KITITAS COUNTY
DEPARTMENT OF PUBLIC WORKS

MEMORANDUM

TO: Patrick Butler, Staff Planner, Community Development Services
FROM: Randy Carbary, Planner II *RC*
DATE: September 18, 2006
SUBJECT: Walker Short Plat

Our department has reviewed the Plat application and has the following comments:

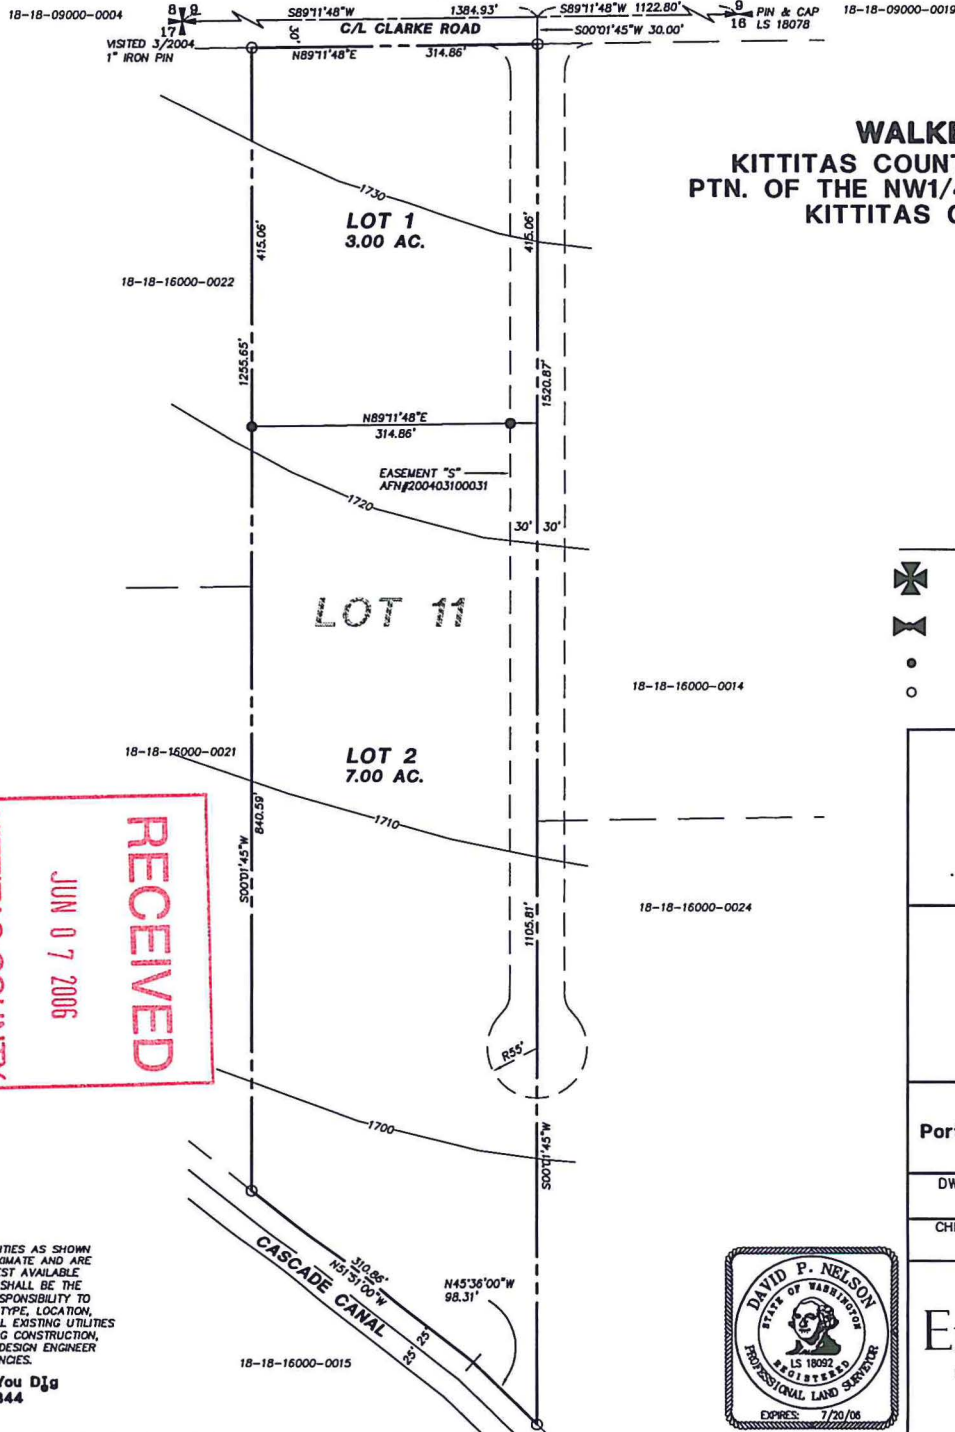
1. Access for Lots 1 and 2: Access for Lots 1 and 2 shall be via the 60' access Easement "S" as shown on the face of the preliminary plat. Access shall meet or exceed all applicable current Kittitas County Road Standards.
2. Private Road Improvements: Access shall be constructed as a Low-Density Private Road. (See current Kittitas County Road Standards)
 - a. Access easements shall be improved to a minimum of 60' as shown on the face of the plat. The roadway width shall be 20', with 1' shoulders = 22' total width.
 - b. All easements shall provide for AASHTO radius at the intersection with a County Road.
 - c. Minimum centerline radius shall be 60'.
 - d. Surface requirement is 6" for gravel surface.
 - e. Maximum Grade is 8% for flat, or 12% rolling or mountainous.
 - f. Stopping Site Distance, reference AASHTO.
 - g. Entering Site Distance, reference AASHTO.

3. Access Easement "S" Private Road: The construction of the Private Road improvements for access easement "S" shall be inspected and certified by a licensed professional engineer for conformance with the current Kittitas County Road Standards. Kittitas County Public Works shall require this Road Certification to be completed, prior to the issuance of a Building Permit for any of the residence within the proposed Walker Short Plat.
